TO: All Staff
FROM: Justin Turnbull, County Surveyor 
DATE: October 15, 2021
SUBJECT: County Survey Review of LPF-21-00010 Tiger Plat

Survey Comments:

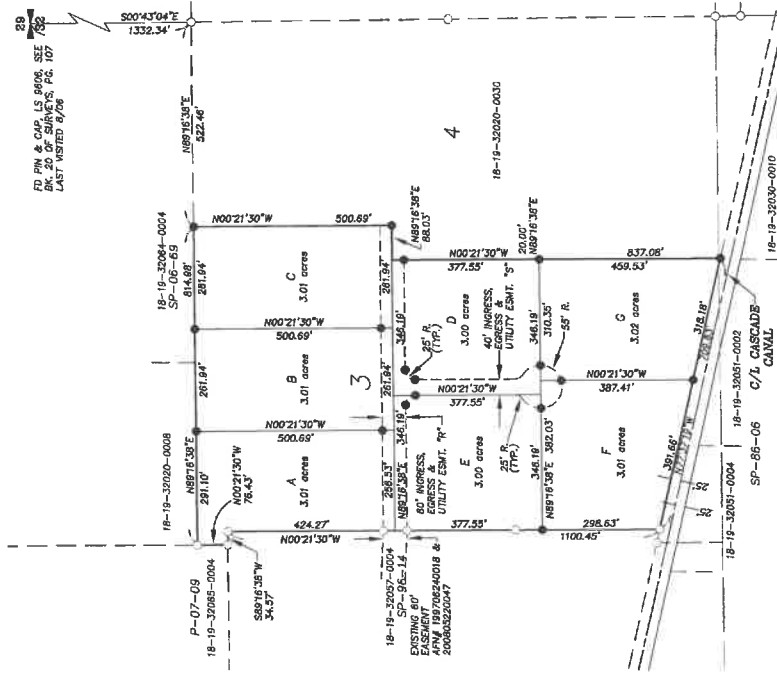
1. Retired Surveyor Stamp, name and signature will need to be replaced with a current licensee. This appears in the recorders certificate, the surveyor's certificate, the stamp, and title block "checked by" location.

2. The owner's dedication will need to be updated with current ownership.
3. The owner will need to be updated with current ownership.
4. Adjacent property owners will need to be updated.

5. County engineer signature will need to be updated with current engineer.
6. There is a label located near the NE corner of Lot G "20.00, N89°16'38"E,. I am uncertain what this is referring to.

7. There are a number of lines that are ambiguous if there are showing distances to lot corners or set corners. These could be cleared up by using "tick marks" or "crows feet". These include: North Lines of Lots F and G, South Lines of Lots E and D, East Lines of Lots D, E and F.

8. There are a total of 7 found corners that do not show distance ties. If any of these corners were utilized as controlling corners, they should include dimensional ties.
